From: Laura Gibbons
Sent: 24 June 2019 09:39
To: Planning.Responses <Planning.Responses@arun.gov.uk>
Cc: Juan Baeza <Juan.Baeza@arun.gov.uk>
Subject: RE: Planning Consultation on: F/11/19/PL

Engineers Comments Regarding Surface Water Drainage

APPLICATION F/11/19/PL

Description of Works: Construction of agricultural barn with flexible storage use (B8 Use Class) with ancillary office space

SFRA: APPENDIX C
FLOOD ZONES

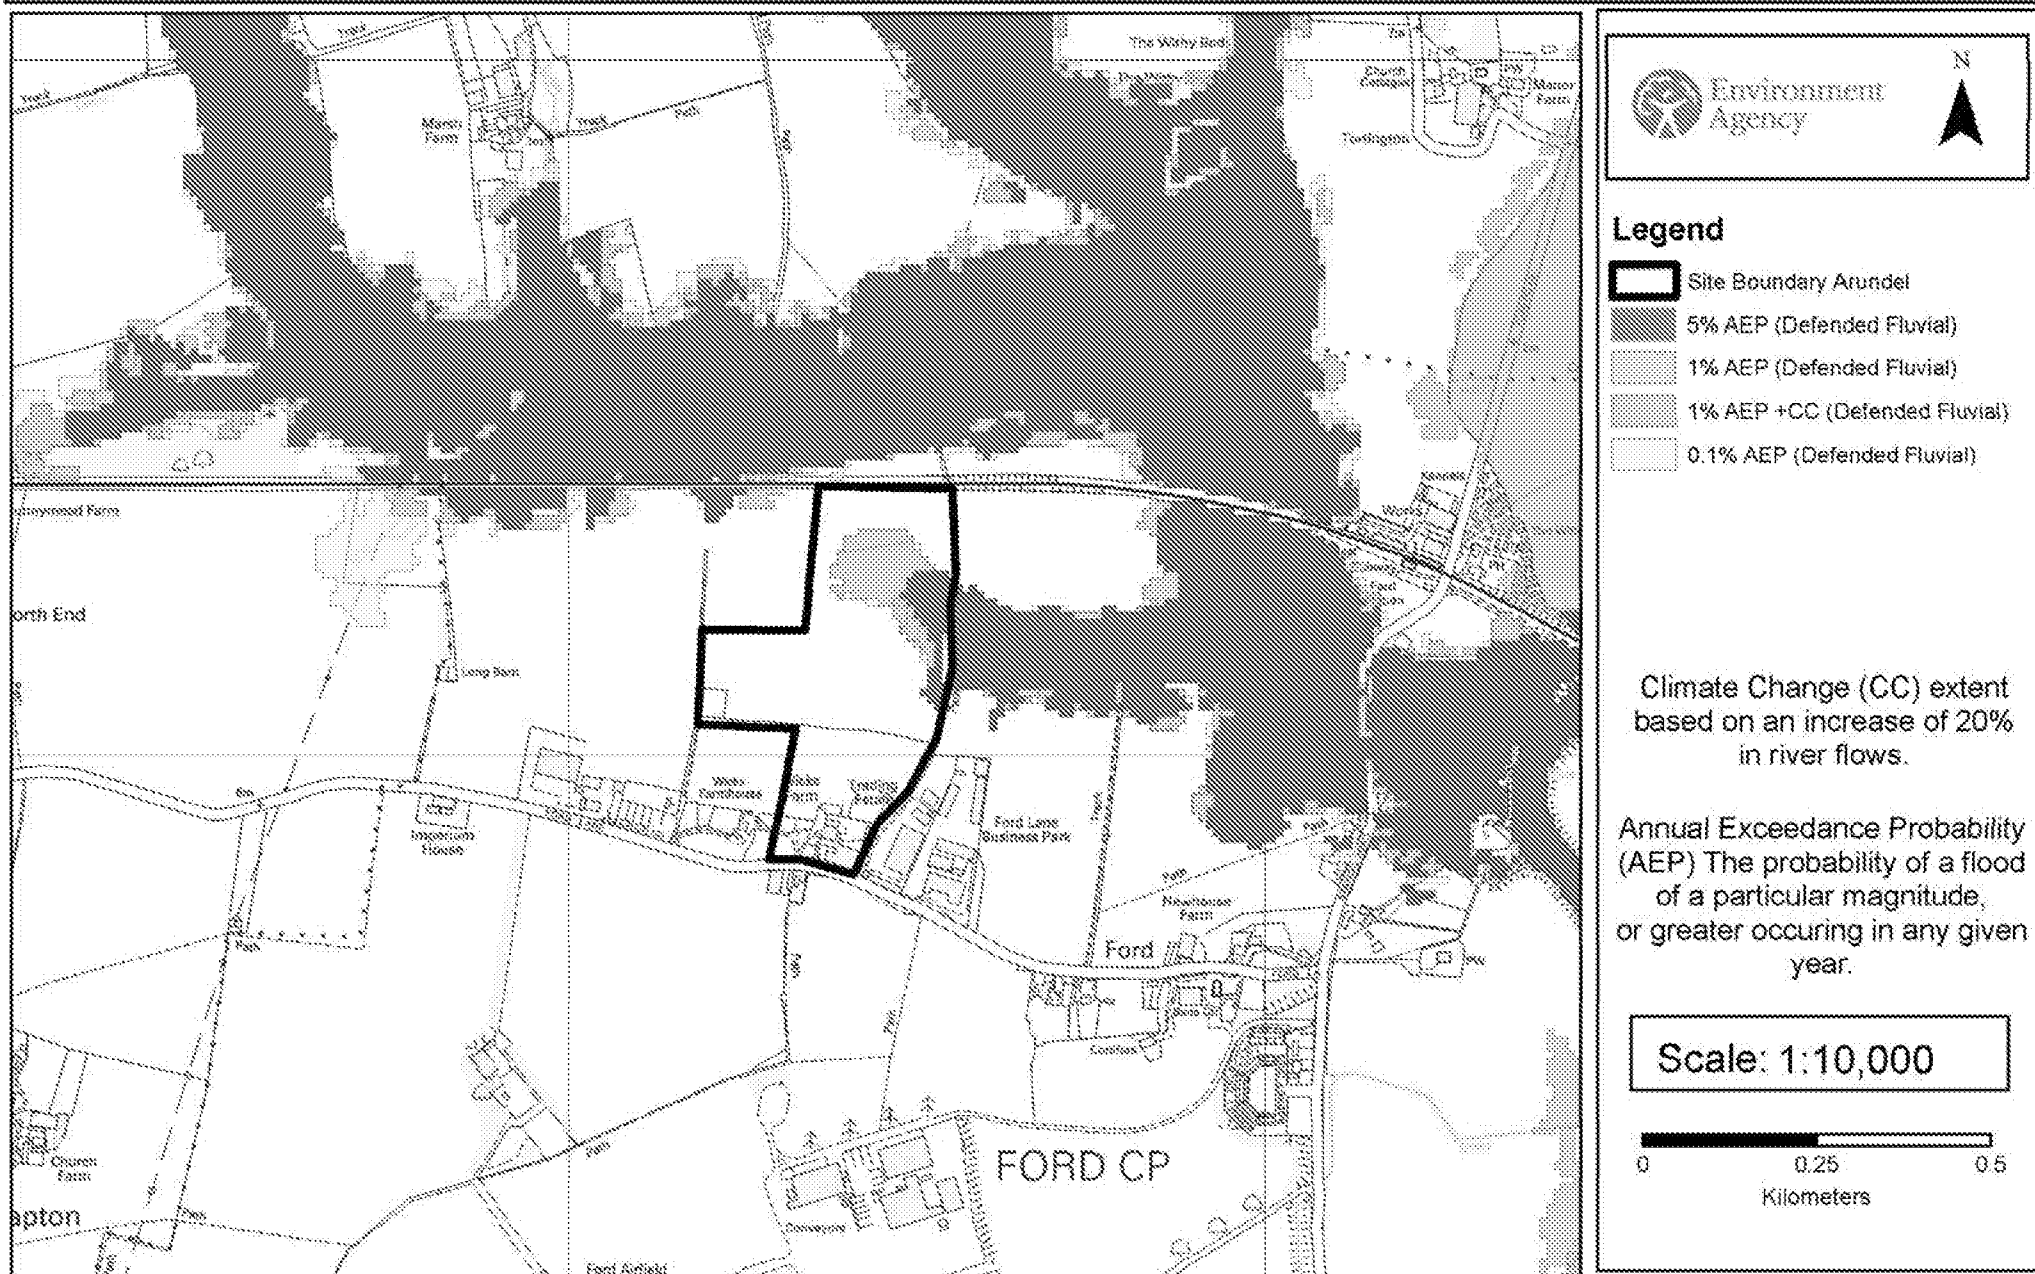
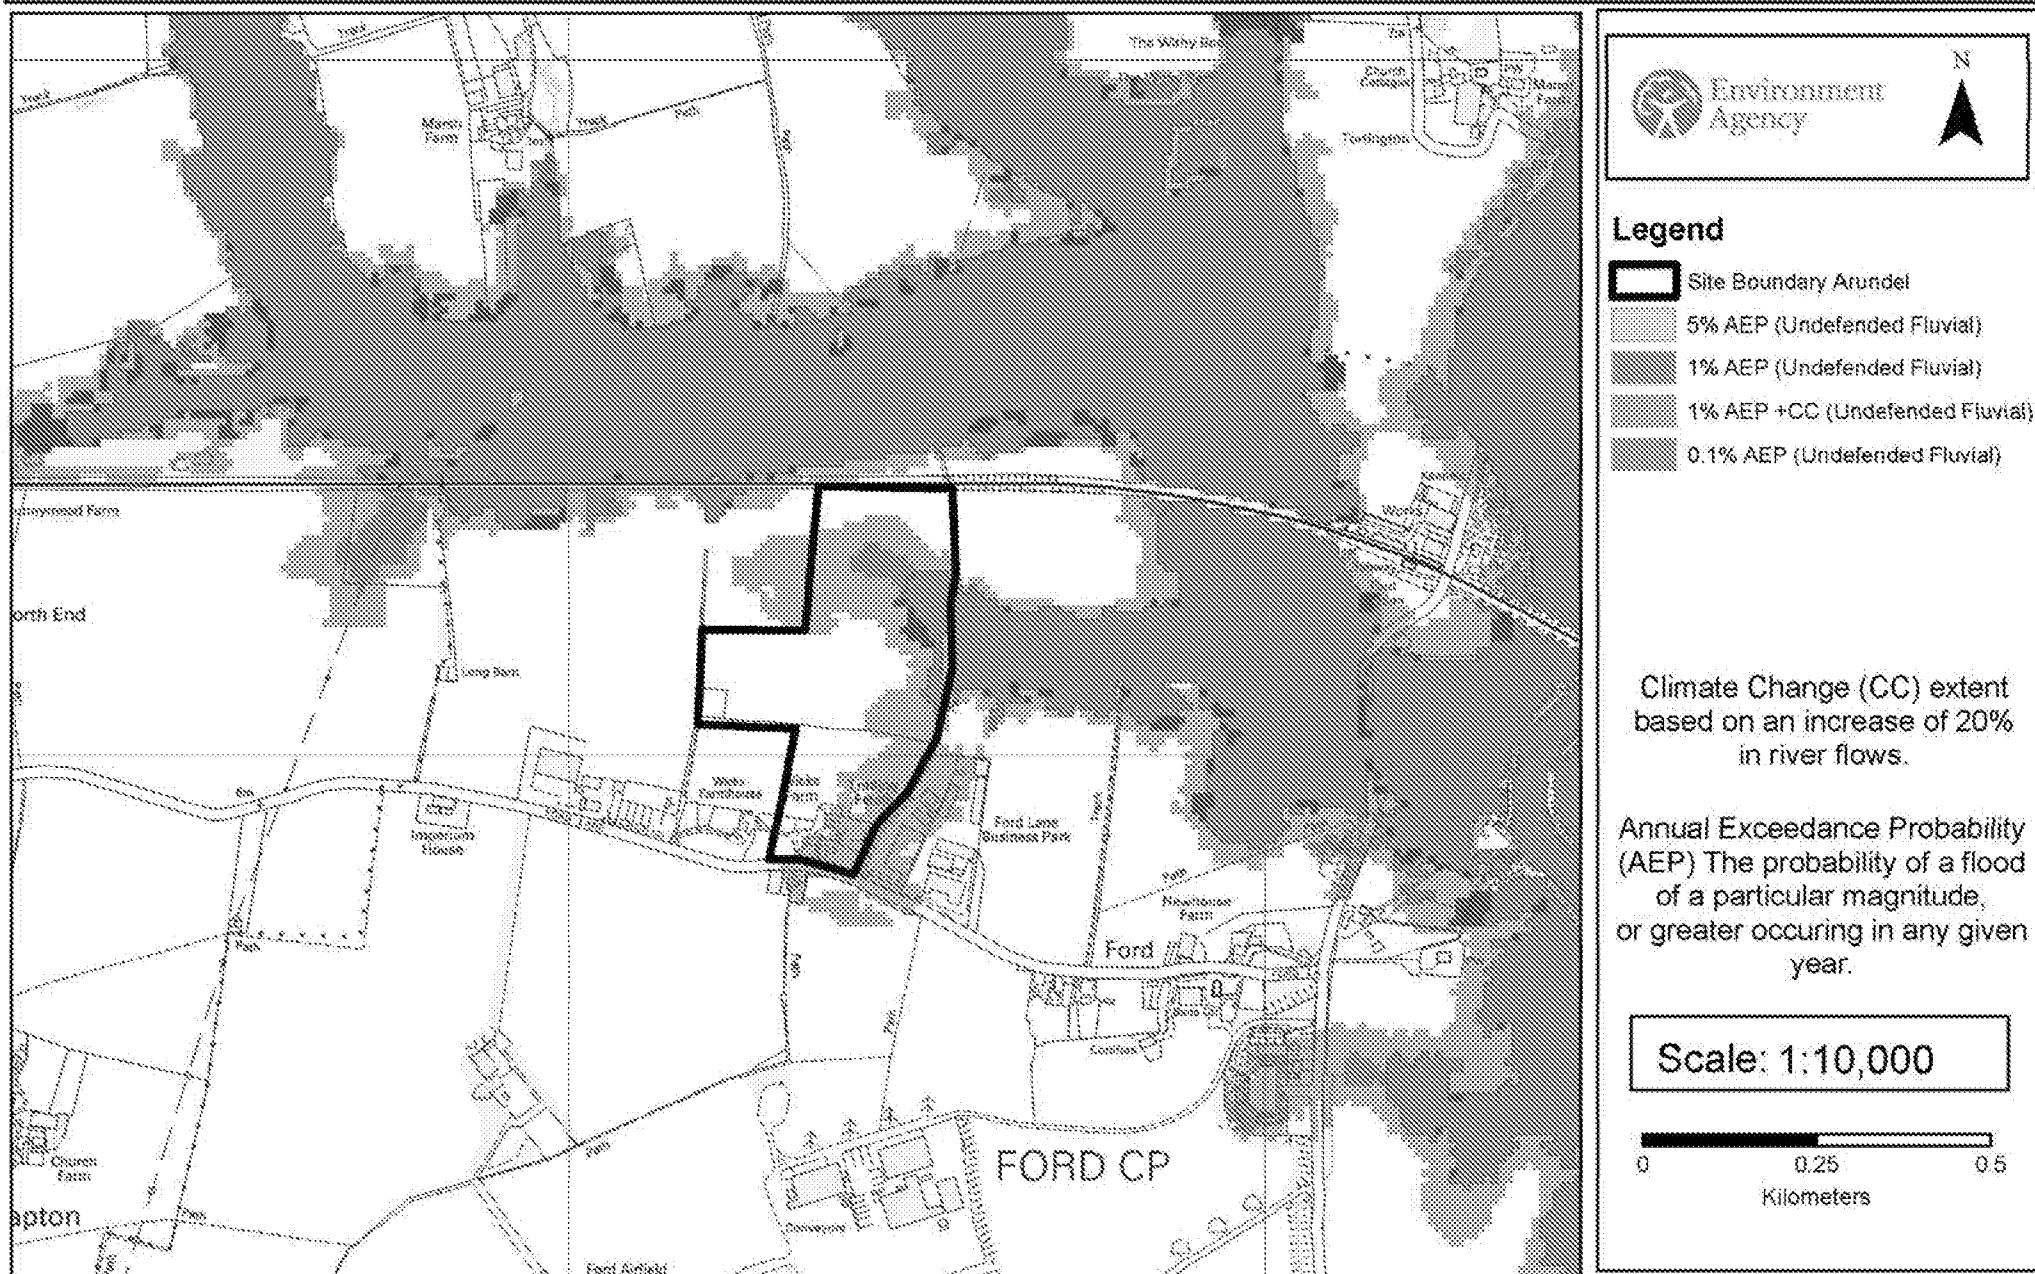
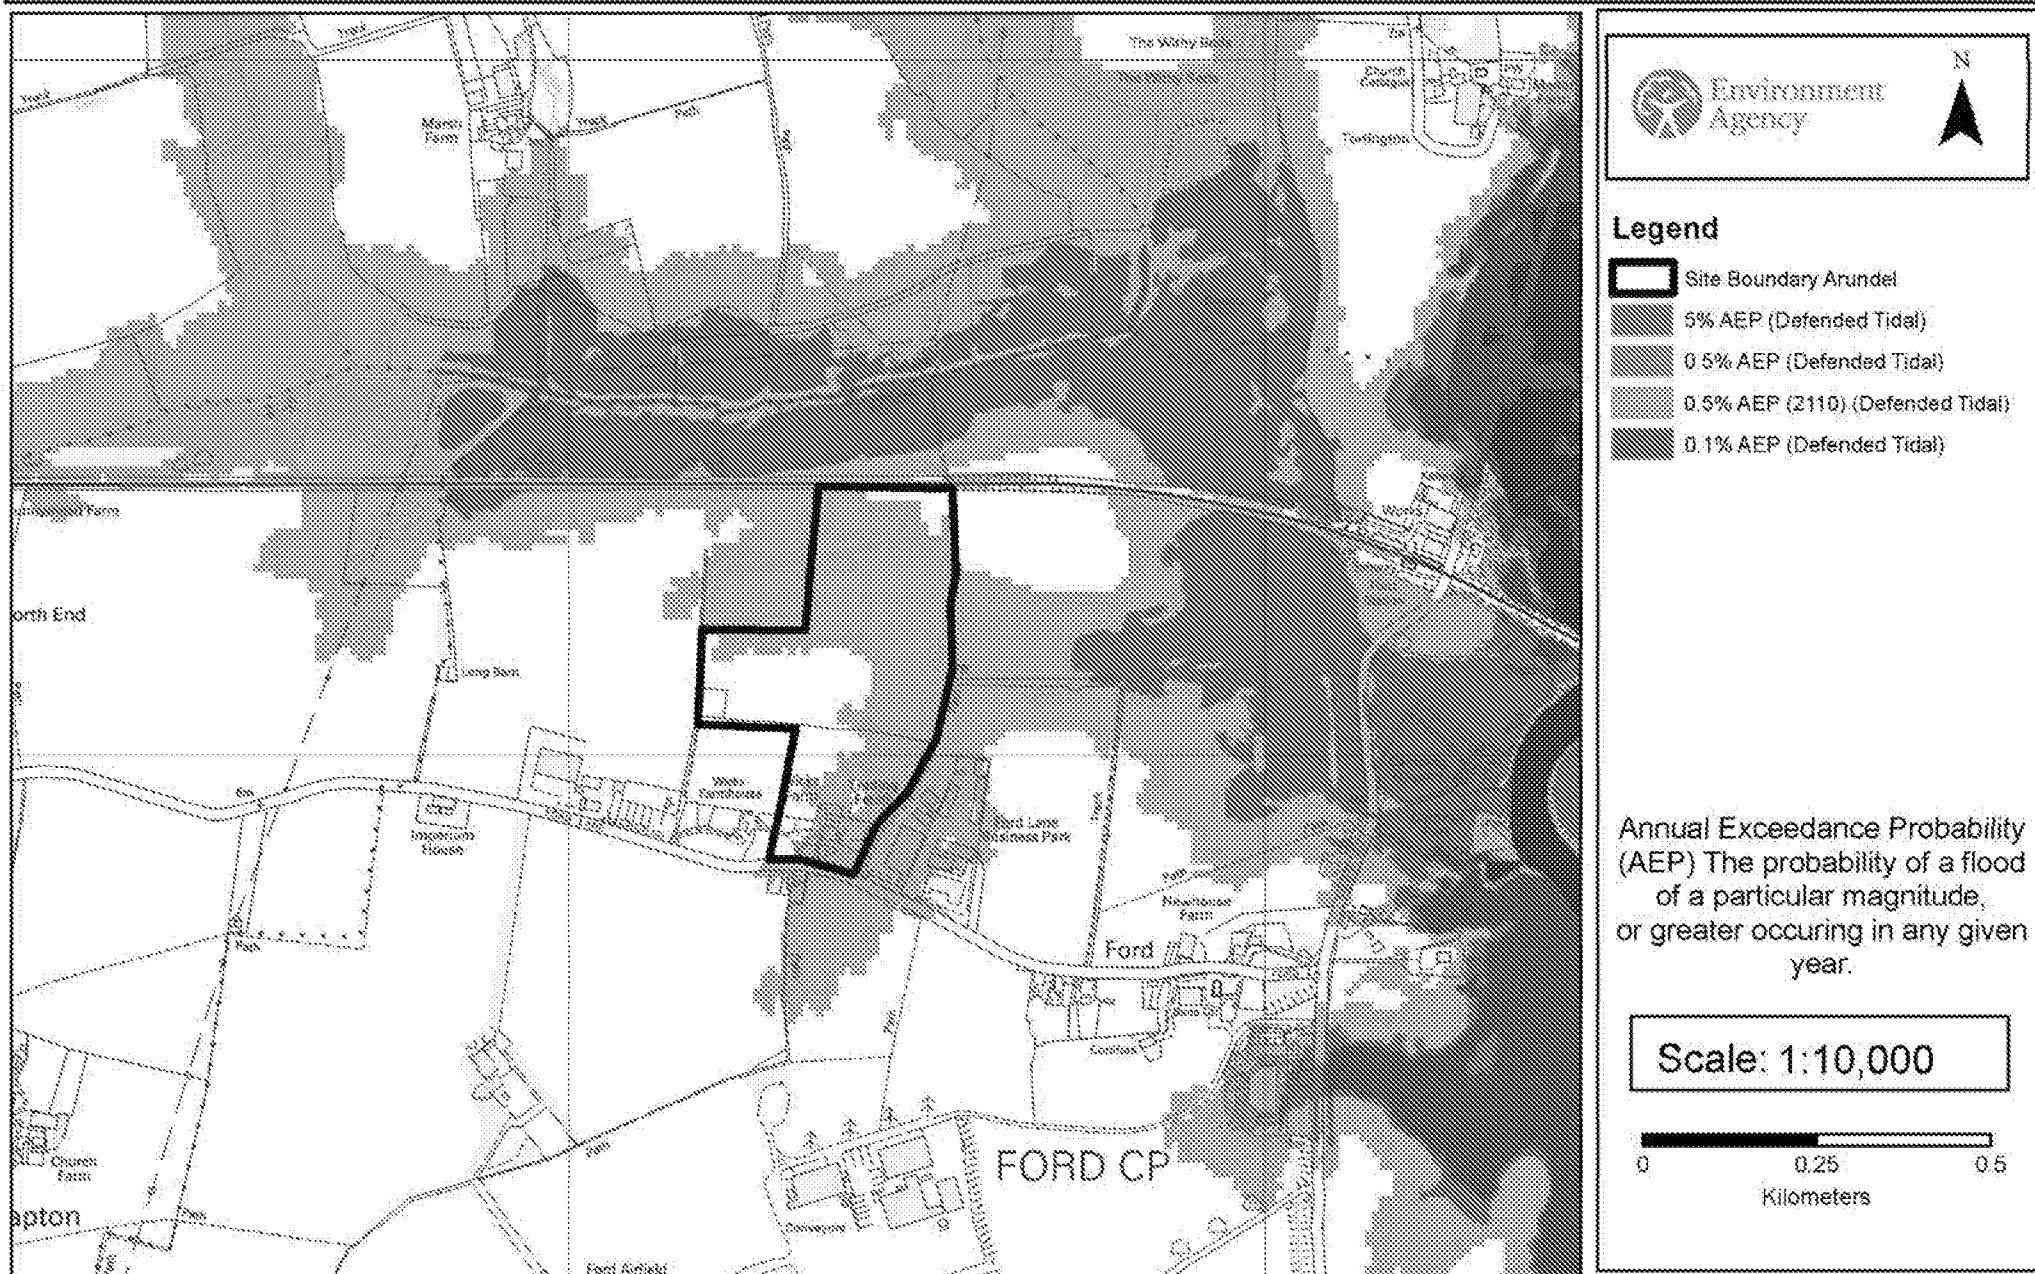
The application has areas within flood zone 1, 2 and 3. The Environment Agency should therefore be consulted. Surface water drainage features should not be located within flood zone 3.
